COUNCIL REFERENCE: SF9367
CONTACT PERSON: Alison Dalyell
YOUR REFERENCE: DA 485-12-2002 MOD 1

**Modification of Residential Subdivision
Lot 5 DP 788159, The Park Drive, Sanctuary Point**

Submission to DA 485-12-2002 MOD 1: 47 Lot Residential Subdivision Nadine St, Sanctuary Point

M:\Projects\20000\26522\Drawings\26522-406-TREES RETAINED.dwg

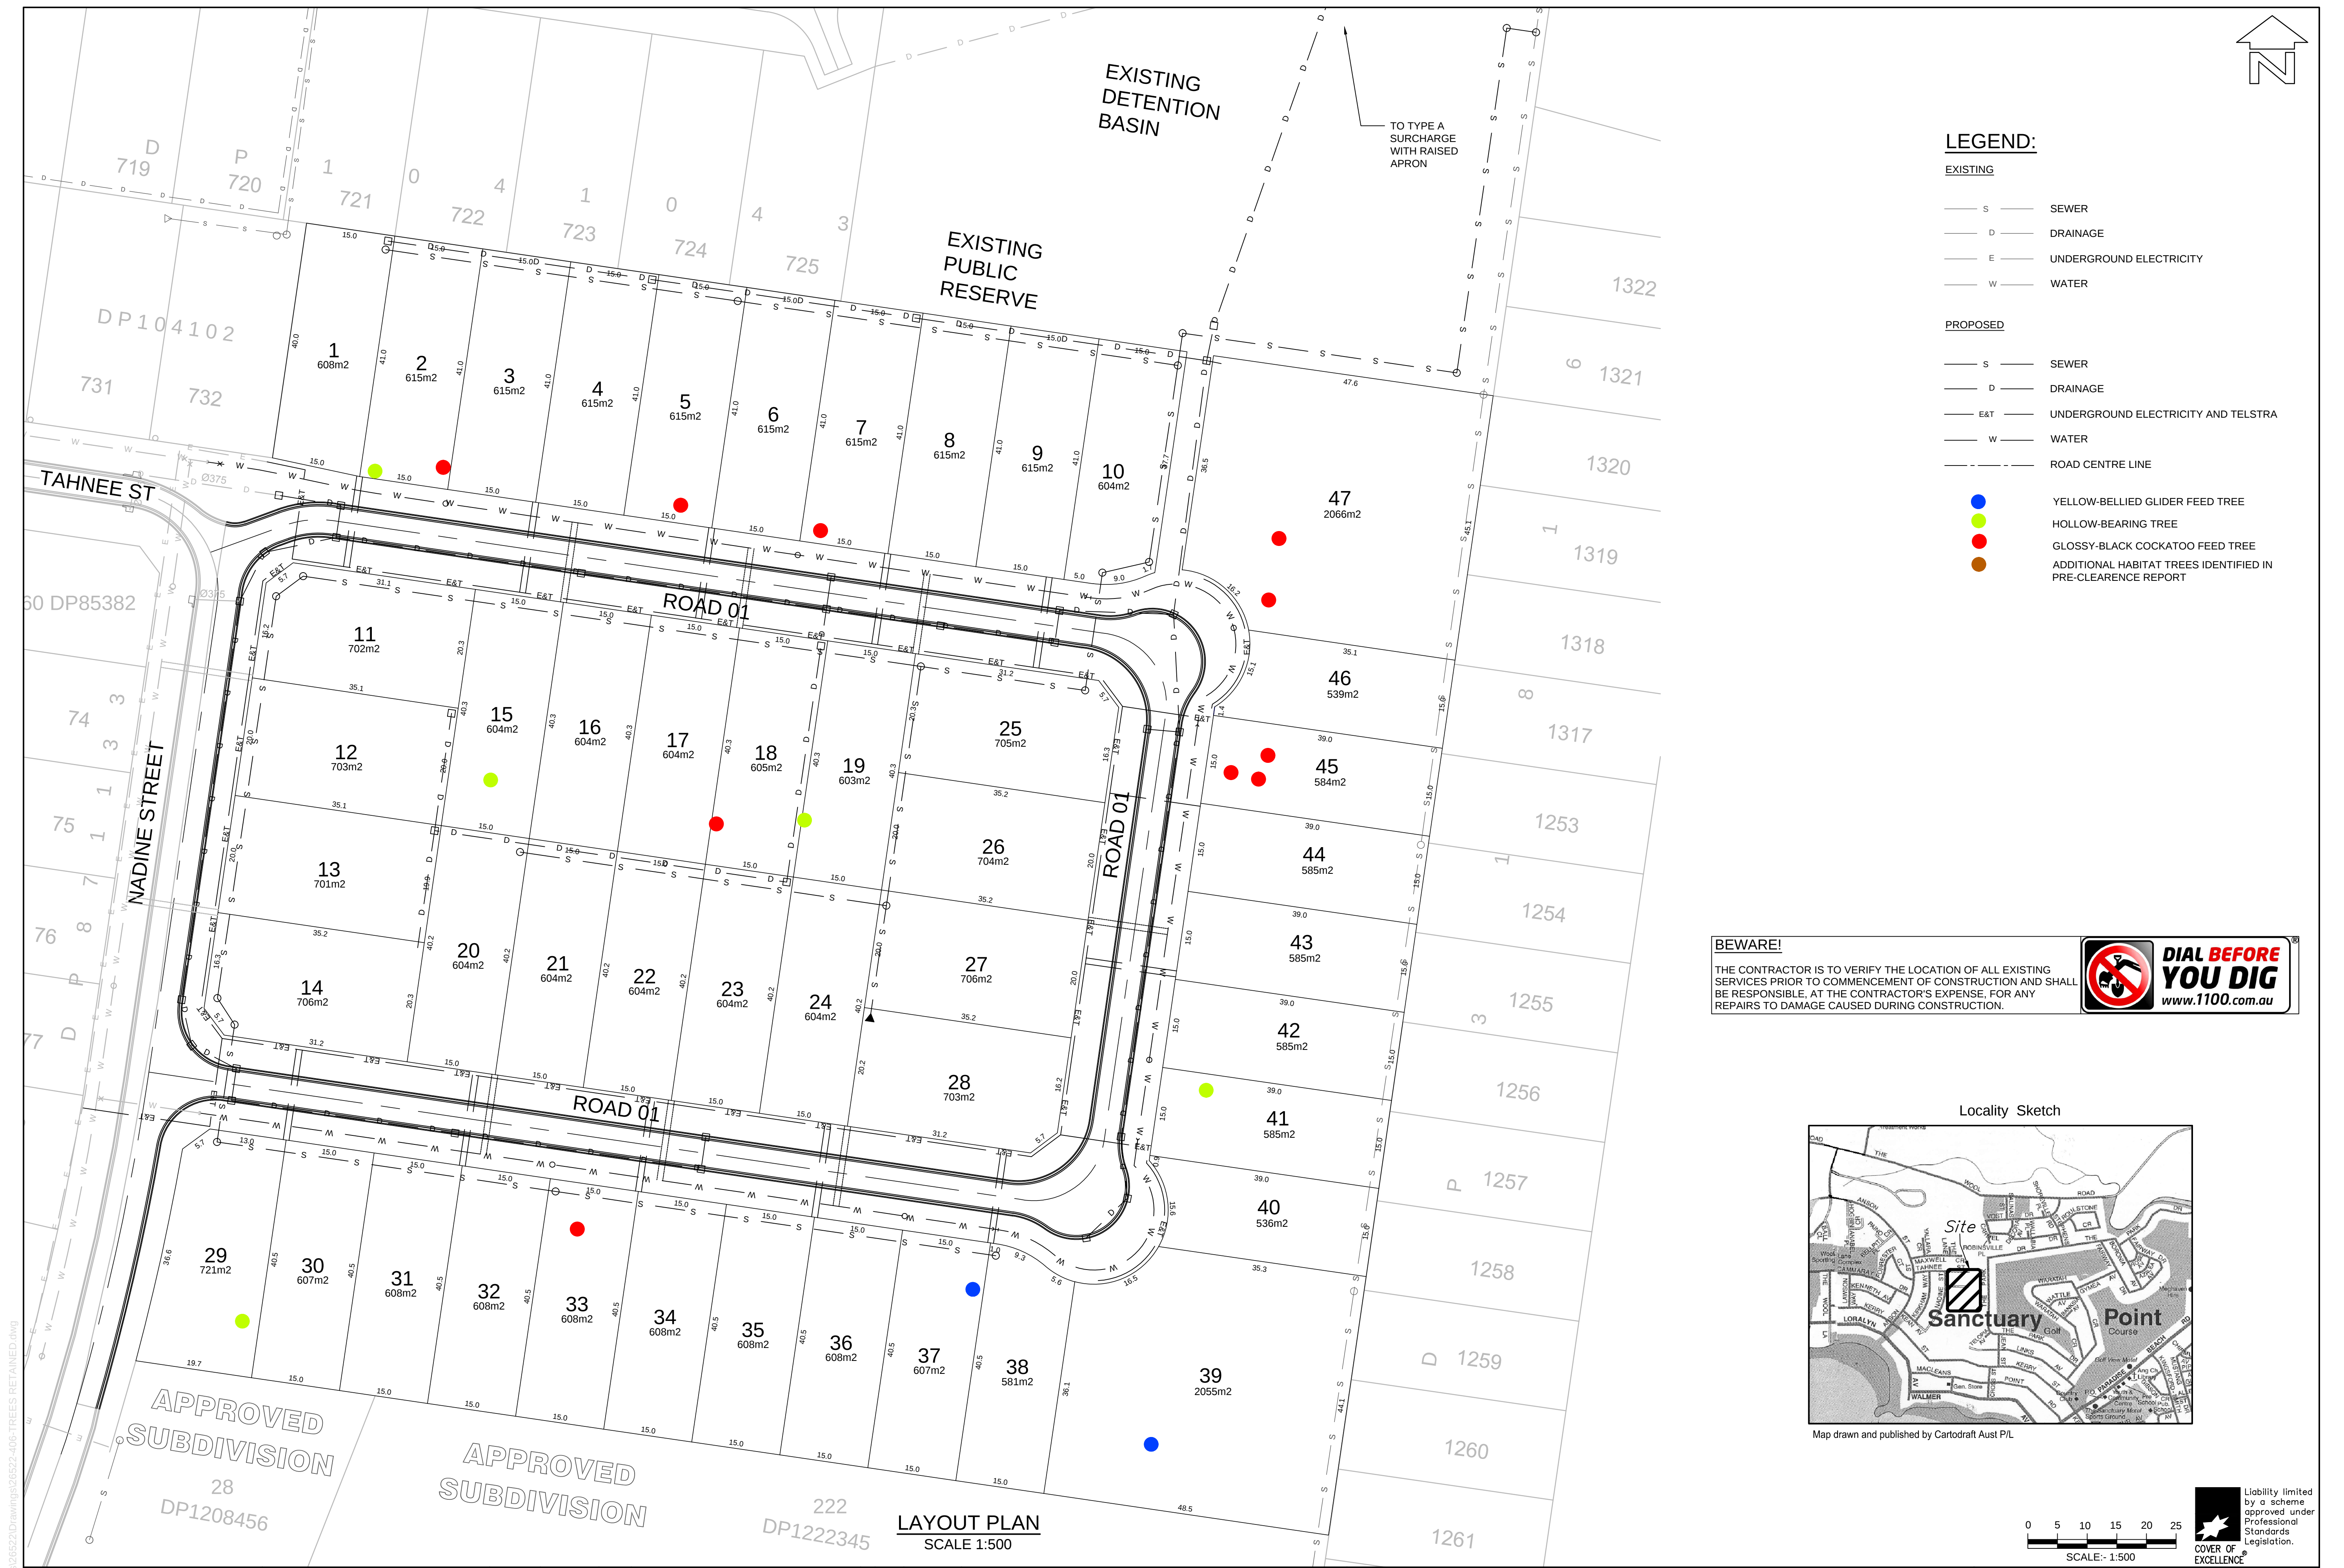
Council notes that the land has been cleared, removal of the remaining trees can be assumed at building stage under the 10/50 rule. As such, the potential impact of the development on the remaining vegetation is evident and that impact must be assessed.

TYPICAL 5m ROAD 01 CROSS SECTION
SCALE 1:50

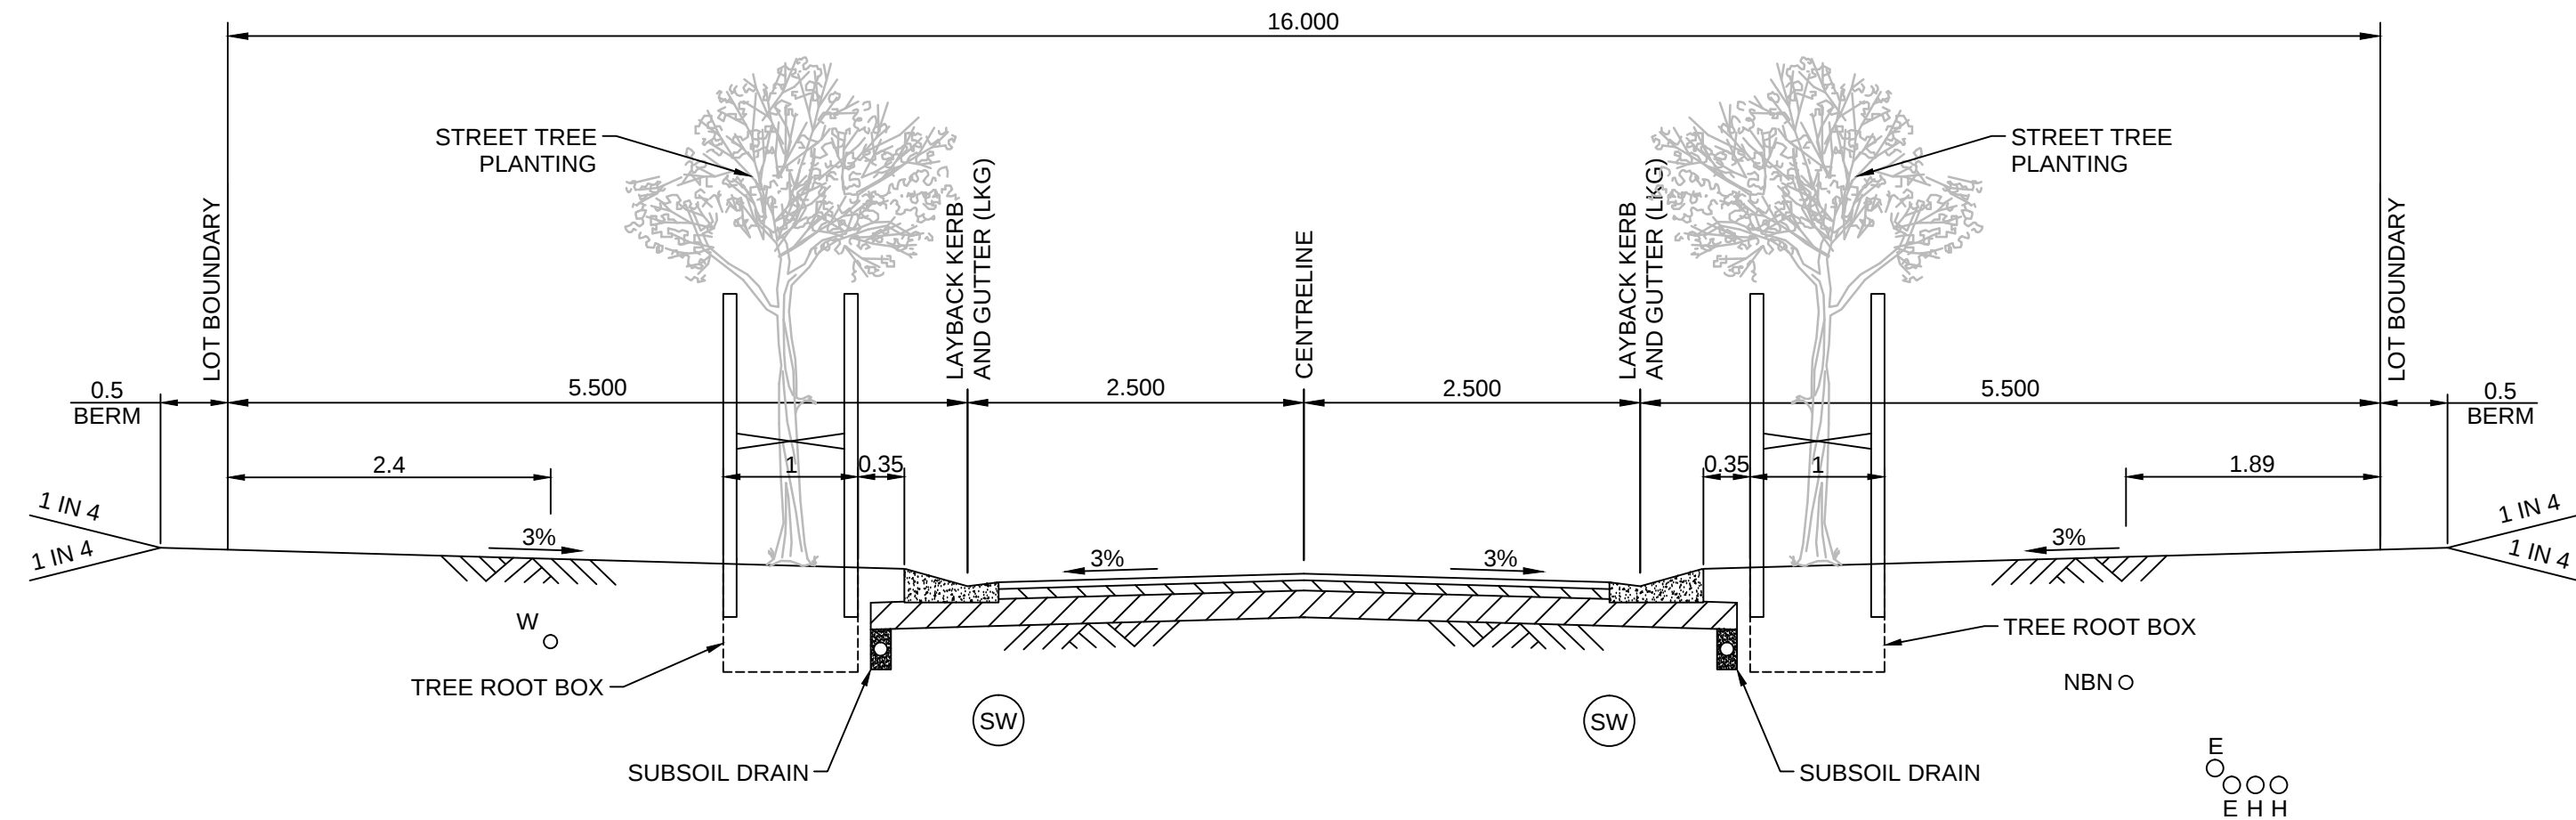
- specifies a pavement width of 5m, the consent does not specify the road reserve width;
- (m) states that *Roads are to be constructed to meet the public road construction requirements outlined in Section 4 of the Planning for Bushfire Protection 2001(PBP2001).*

PBP2001 section 4.3.1 Public Roads dot point 2 requires that *Roads should be two-way, that is, at least two traffic lane widths (8m minimum) with shoulders on each side, allowing traffic to pass in opposite directions.* This requirement obviously applies to the trafficable width of the road, i.e. the pavement. The approval for a 5m pavement in condition B2 (a) is clearly a significant concession to PBP2001 requirements. A similar concession was not applied to the width of the road reserve. Furthermore, the pavement width is less than that required in Council's Development Control Plan 2014, i.e. minimum pavement width for a Local Road is 6m.

A 5m pavement width will result in the use of the nature strip for car parking, contrary to the NSW Road Rules 289 *Driving on a Nature Strip* and 197 *Stopping on a nature strip*. The narrower the roadway the more likely it is that motorists will stop (park) on a nature strip.

PROPOSED RESIDENTIAL SUBDIVISION

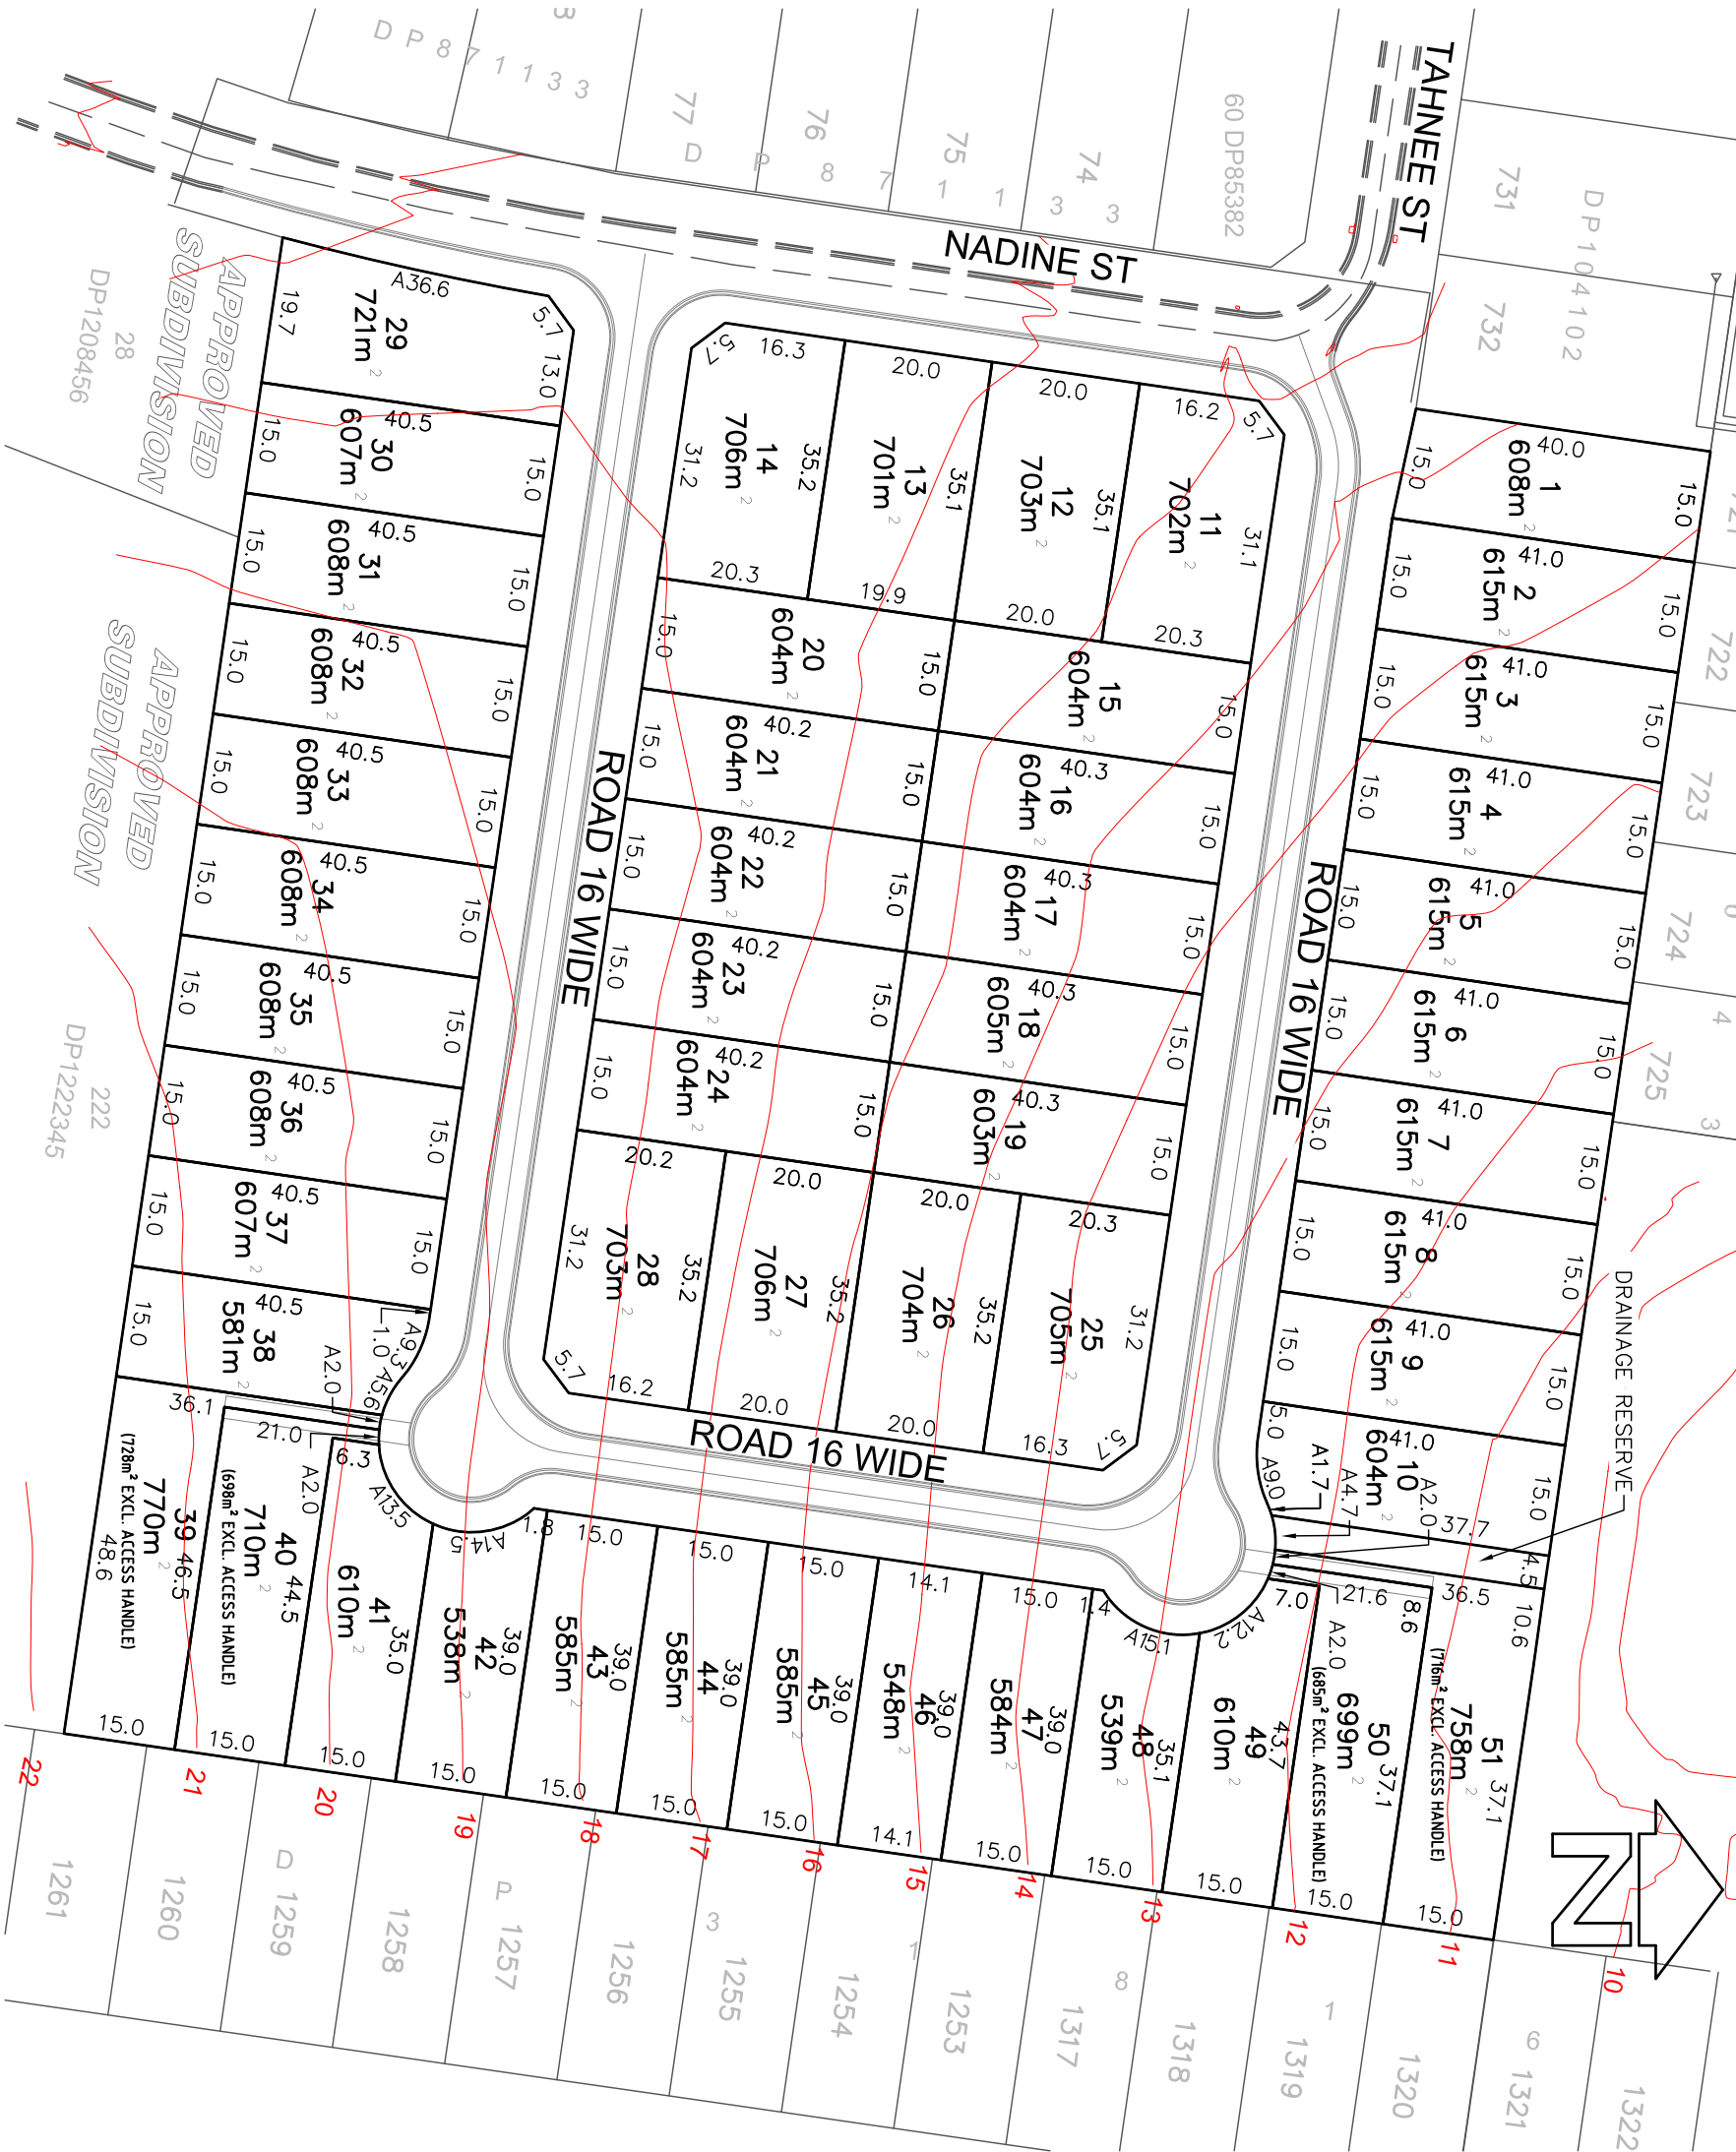
The revised plan of subdivision includes the road widths. No other changes have been made.

The size of Lots 39 and 47 are 2055m² and 2066m² respectively. The size creates an expectation that they are potentially suitable for medium density development. As previously stated, the road frontage to these lots is inadequate for higher density development. If it is

the intention of the proponent to provide medium density lots, alternative lots of equivalent size and with full road frontage could be identified.

The proposed road reserves originally approved at 18m remain at 16m. None of the surrounding through roads are less than 18m unless they are a cul-de-sac.
